DRB Application No.: 07 DRB - 70137 Project # 1006586  
 Project Name: ~~SUNDEEP SOUTH UNIT 9~~  
 Agent: SEVEN BAR THOMPSON ENG. Phone No.: \_\_\_\_\_

**4. Project# 1006586**  
07DRB-70101 VACATION OF PUBLIC EASEMENT  
07DRB-70109 VACATION OF PRIVATE EASEMENT

THOMPSON ENGINEERING CONSULTANTS, INC agent(s) for WILLIAMS DEVELOPMENT, LLC request(s) the above action(s) for all or a portion of Tract(s) D-4-L-1 & D-4-L-2B, **SEVEN BAR RANCH**, zoned SU-1/IP, located on CALLE CUERVO NW BETWEEN ELLISON DR NW AND CORRALES RD NW containing approximately 3.72 acre(s). (A-14)

### 07DRB-70137 MINOR - PRELIMINARY/ FINAL PLAT APPROVAL

(BEING A REPLAT OF TRACTS D-4-L-2B & D-4-L-1, SEVEN BAR RANCH)

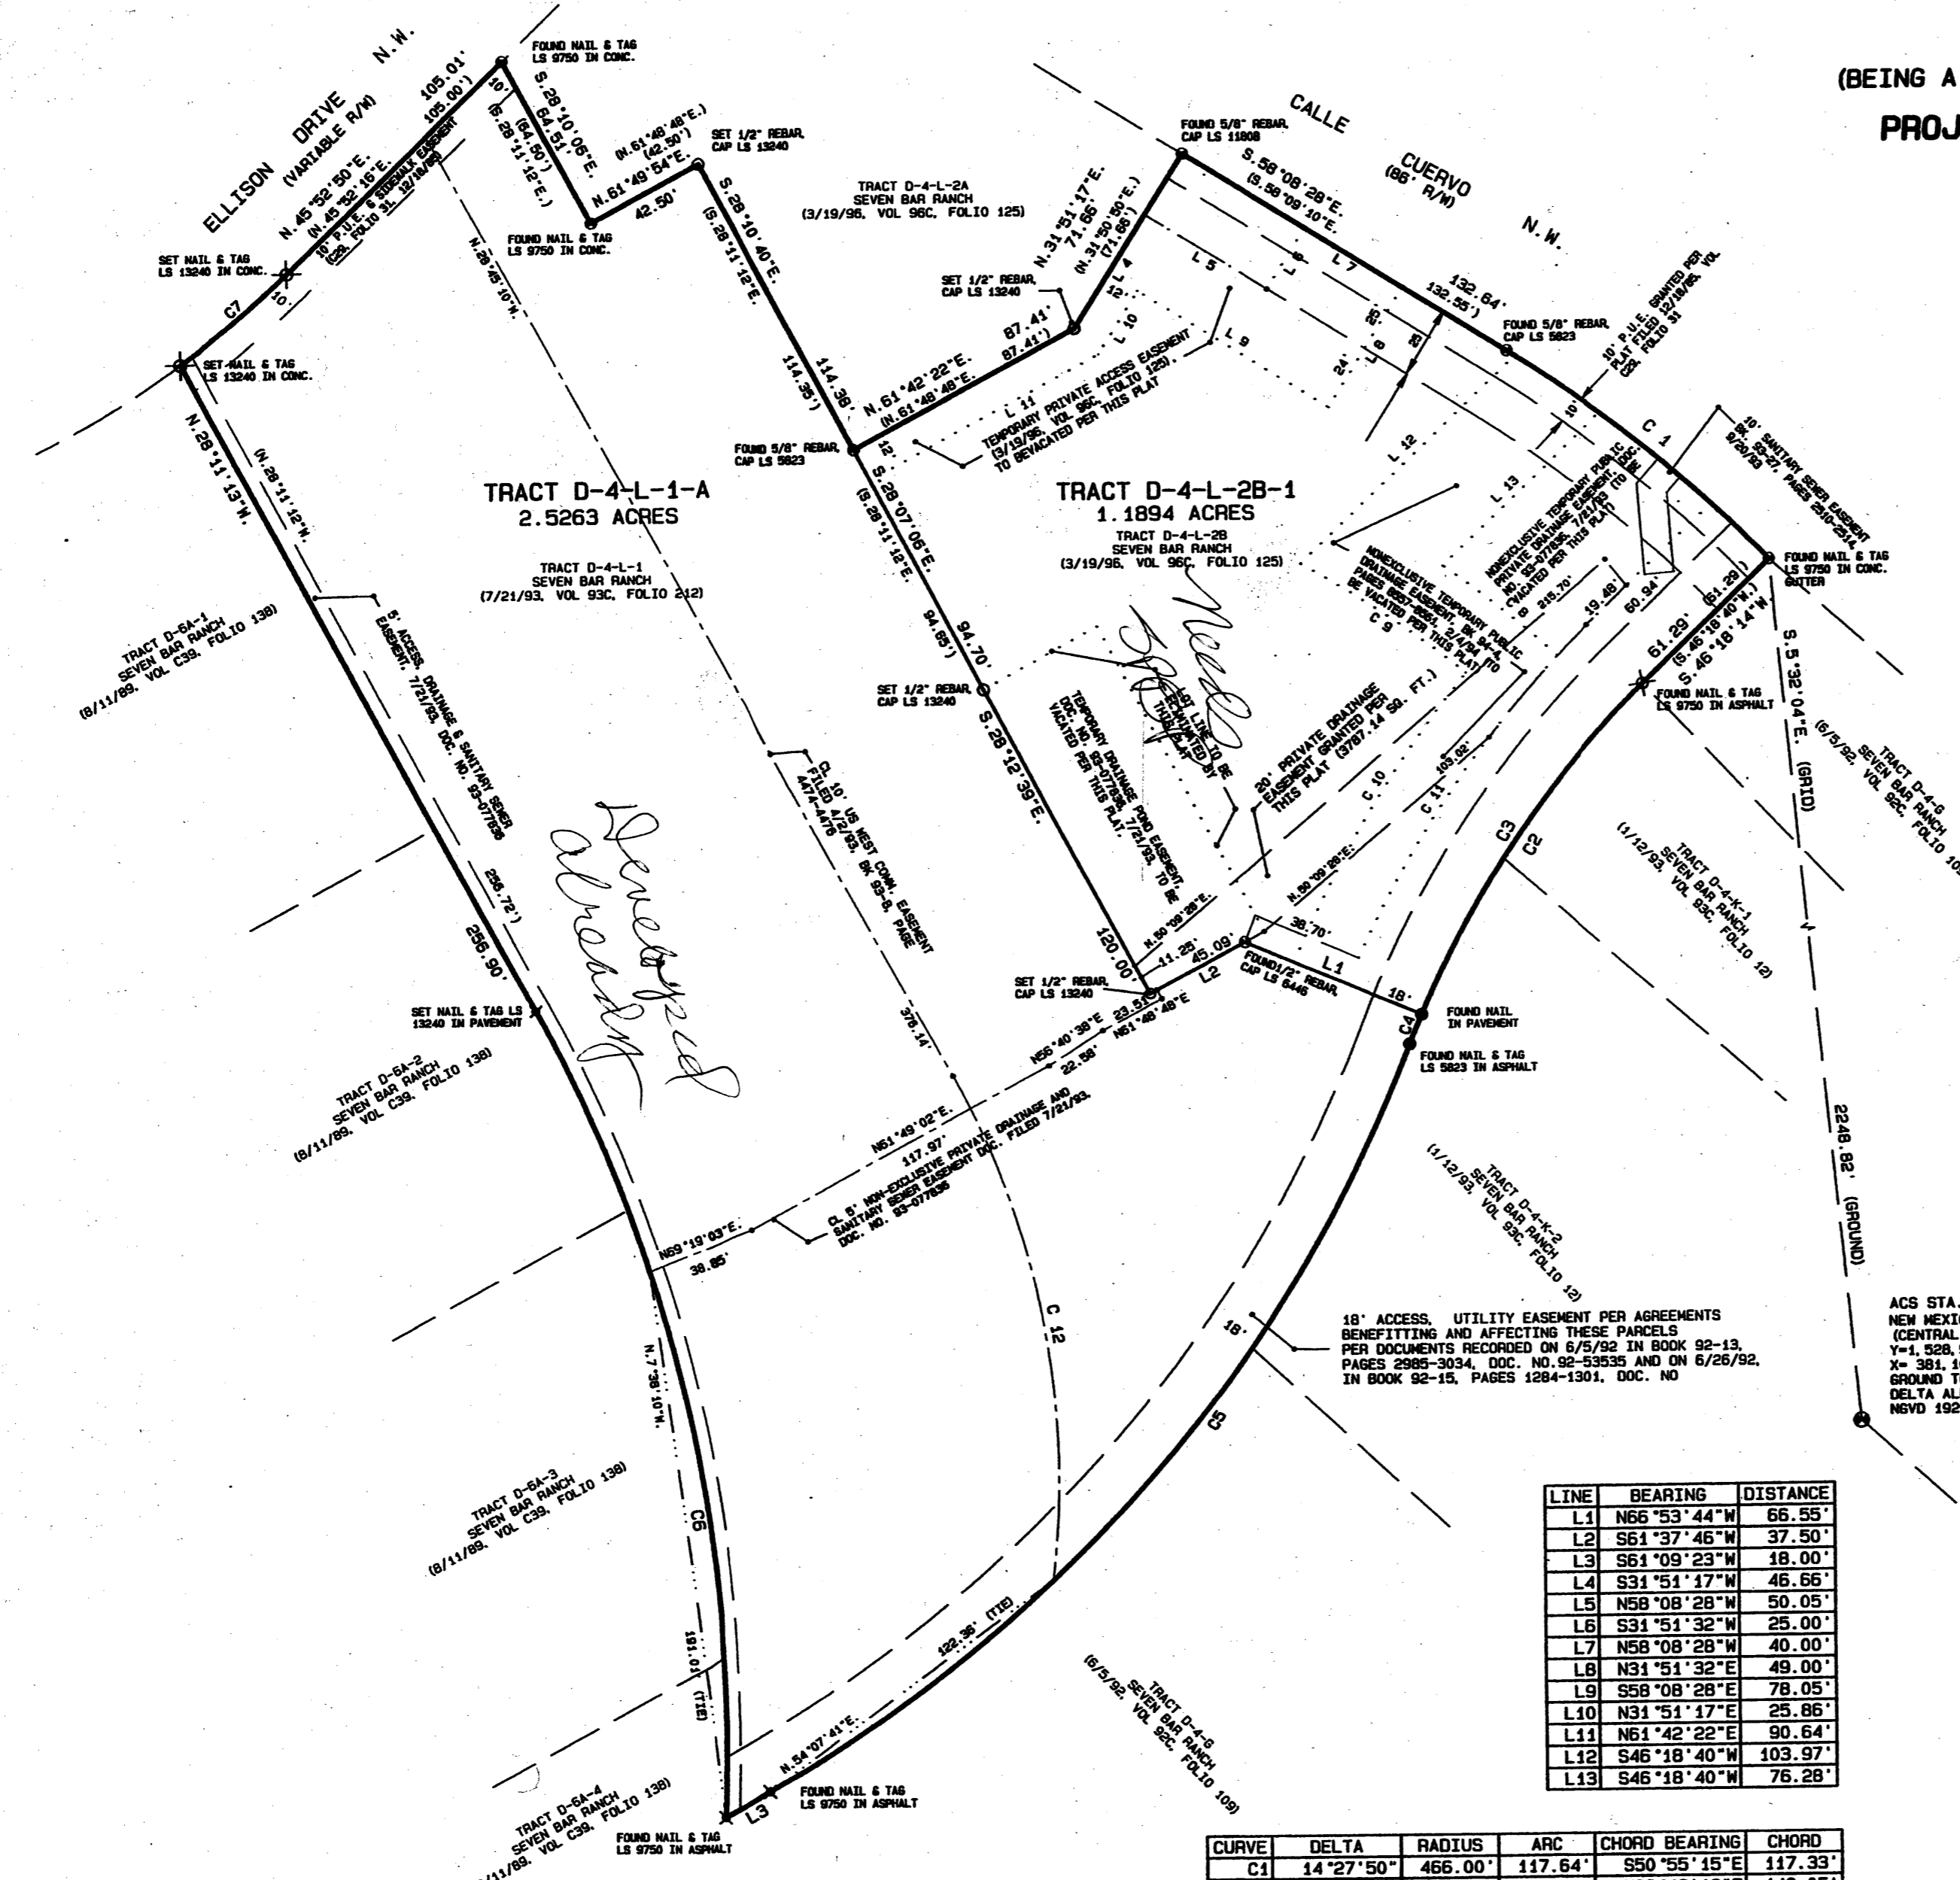
An approved conceptual grading and drainage plan dated 7-11-07 is on file for Preliminary Plat approval.  
A cross lot drainage easement is required. *ok M+BB*

A site plan is needed to show why the access easement can be vacated.  
Defer the other requests to Hydrology.

CITY ENGINEER / AMAFCA: M: B on private drainage easement.  
 \_\_\_\_\_  
 \_\_\_\_\_  
 \_\_\_\_\_
